**WEST SUSSEX COUNTY COUNCIL
STRATEGIC PLANNING CONSULTATION**

SUBJECT: LU/94/17/OUT-Outline application with all matters reserved for residential re-development comprising of 10 No. dwellings & associated works (resubmission following LU/327/16/OUT).

Westholme Nursery, Toddington Lane, Littlehampton, West Sussex, BN17 7PP

Site/Block Plan
As Existing

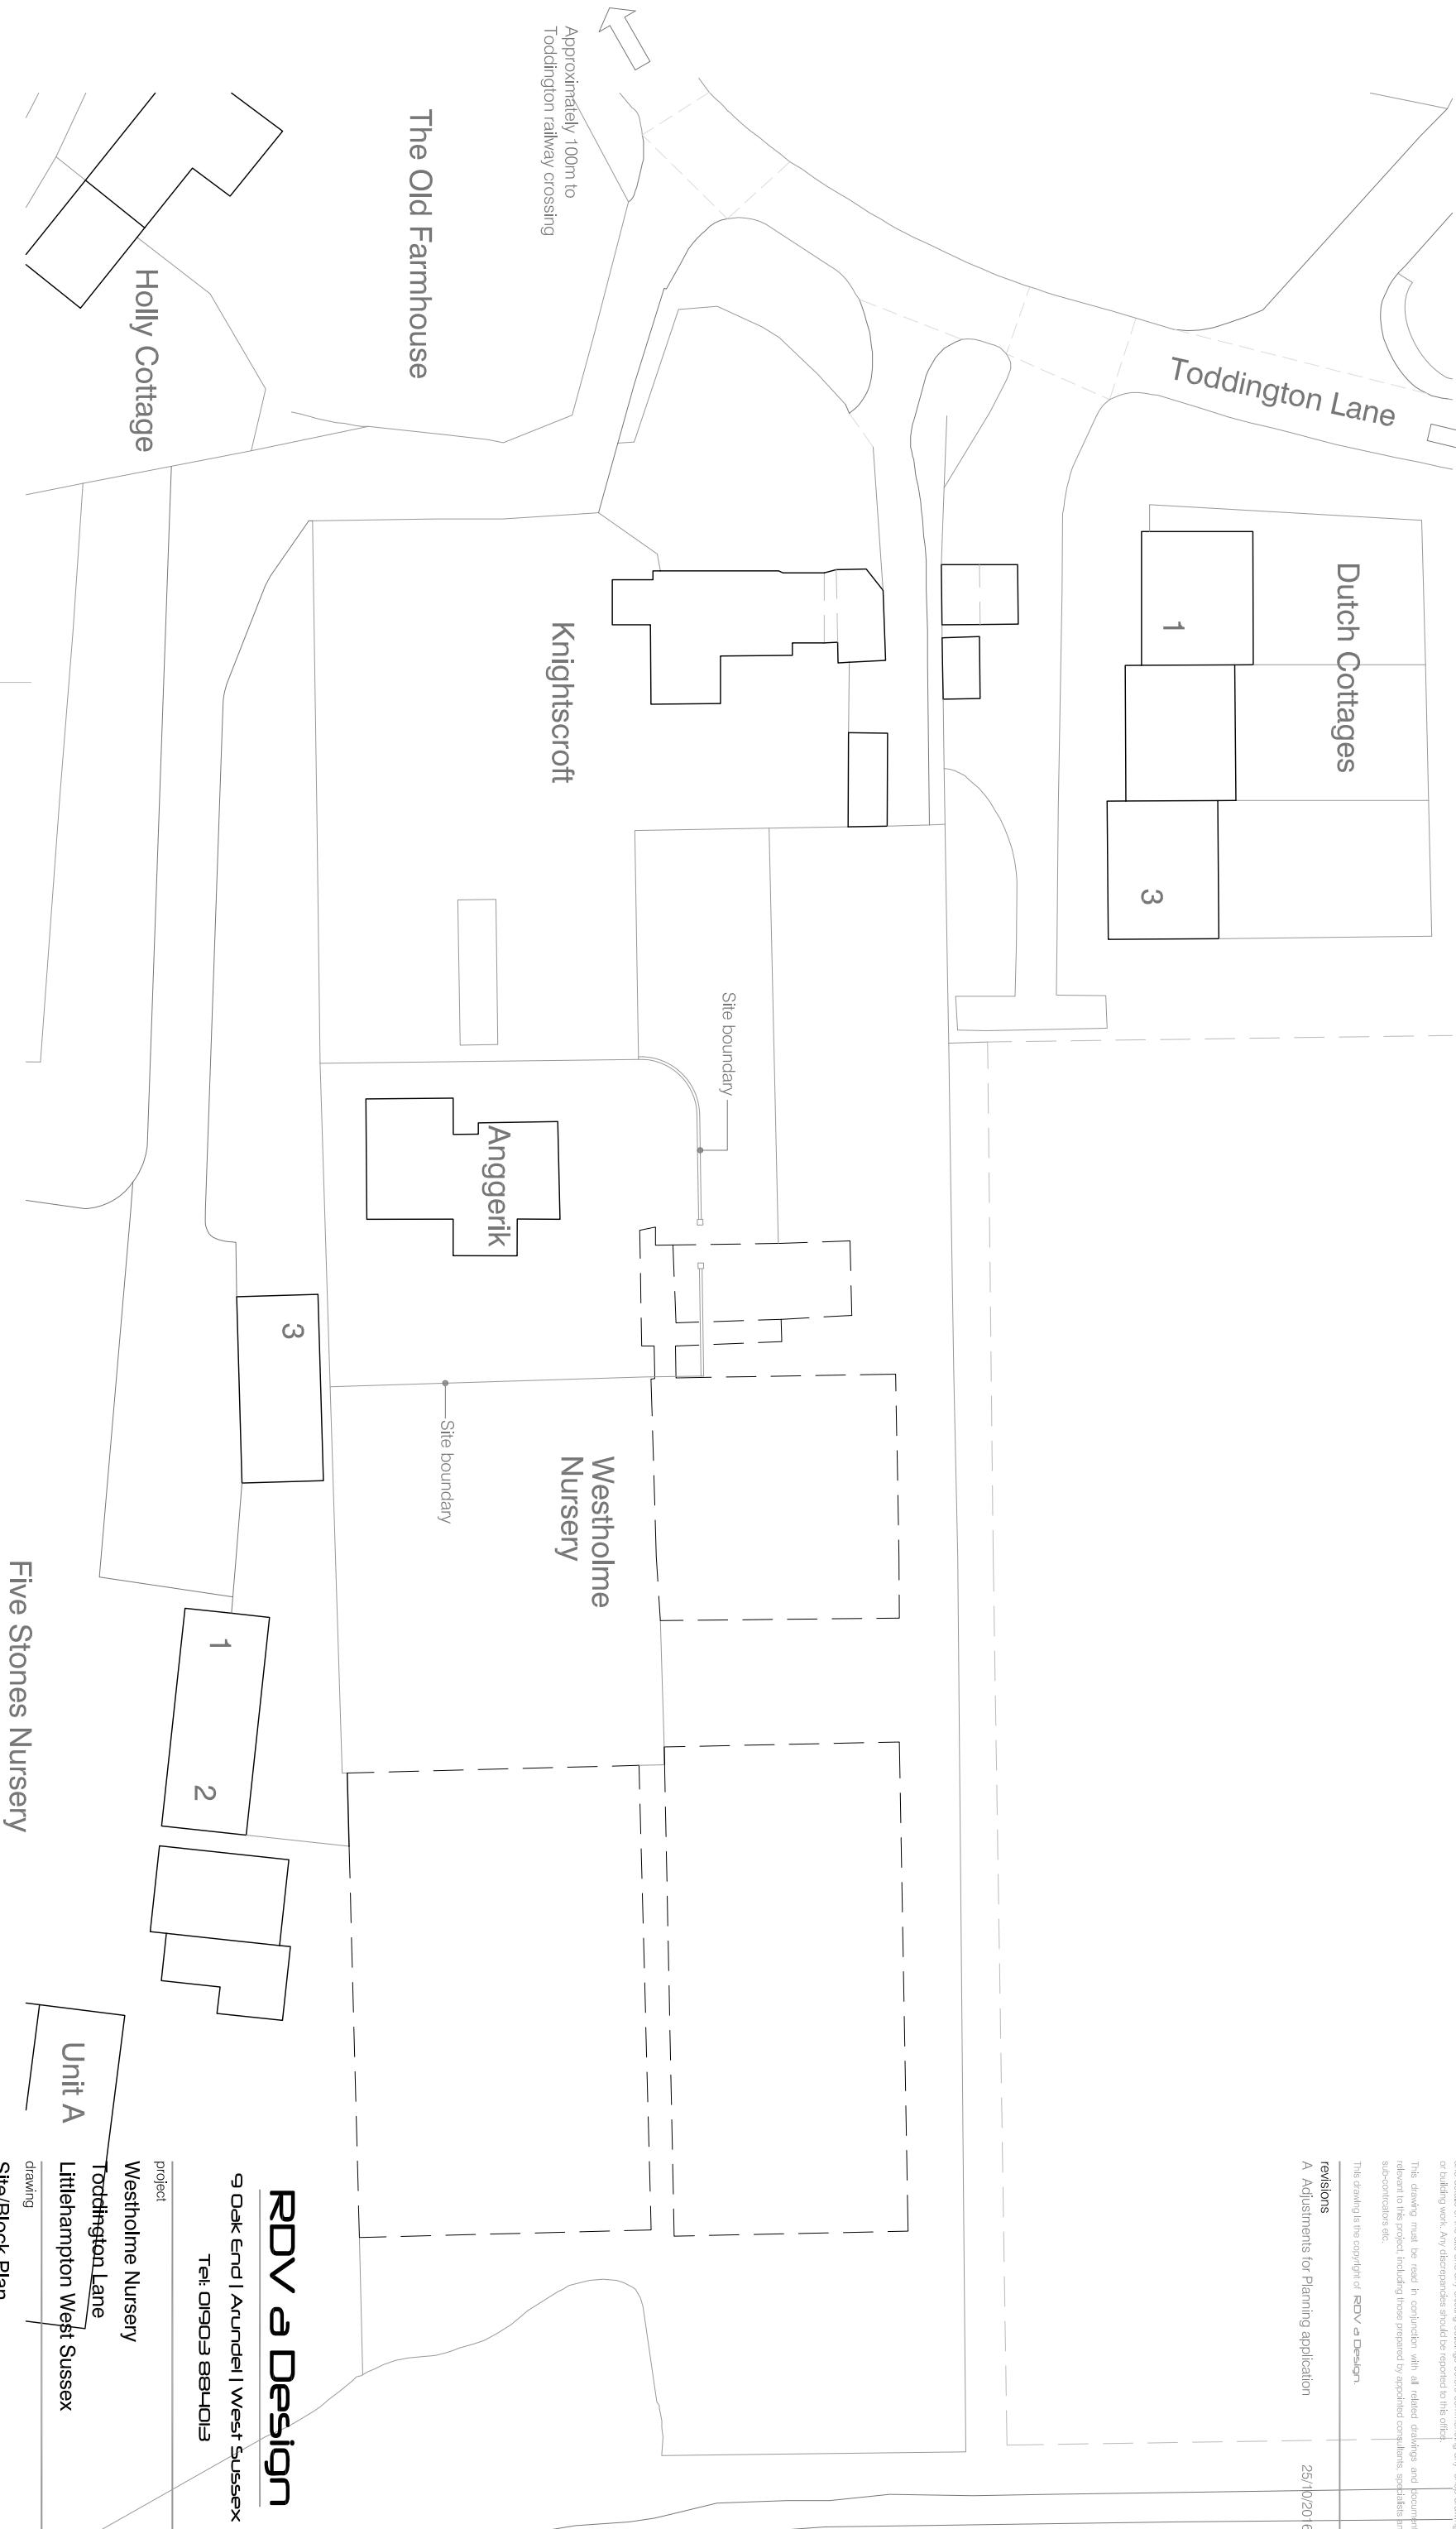
The scheme proposes access from an existing vehicular crossover onto Toddington Lane. Whilst it is stated there will not be any changes to the access, it does appear at present to require some upgrading in the form of surface improvements for the proposed usage. These works would be undertaken with a licence agreement with the WSCC Implementation Team under a Section 278 Agreement. The access appears have the provision visibility splays of 2.4 by 43 metres indicated. The splays provided are considered acceptable for the 30 mph speed limit. Based on the information within the supporting statement it would appear the site will be serviced by a refuse vehicle.

Swept path diagrams were requested demonstrating how larger vehicles can safely enter the site. This has still not been provided, having measured the submitted plan there does appear to be sufficient space for larger vehicles to turn within the turning head to the east of the site, however this could require some modification and enlargement of the design. We are satisfied that this can be provided via a condition to any planning consent, ensuring the design of the access road takes into account refuse collection vehicles.

The application form does not indicate if the internal road will be offered for adoption. In principle, the layout would be acceptable subject to detailed design and the demonstration of adequate turning facilities. The access road would be acceptable to work as a 'Shared Surface' environment, this would be sufficient for the low speeds anticipated. Parking provision does meet the requirements of the WSCC Parking Demand Calculator, we are satisfied with the provisions provided.

No part of the development shall be first occupied until the car parking has been constructed in accordance with the approved site plan. These spaces shall thereafter be retained at all times for their designated purpose.

No part of the development shall be first occupied until visibility splays of 2.4 metres by 43 metres have been provided at the proposed site vehicular access onto Toddington Lane in accordance with the approved planning drawings. Once provided the splays shall thereafter be maintained and kept free of all obstructions over a height of 0.6 metre above adjoining carriageway level or as otherwise agreed.
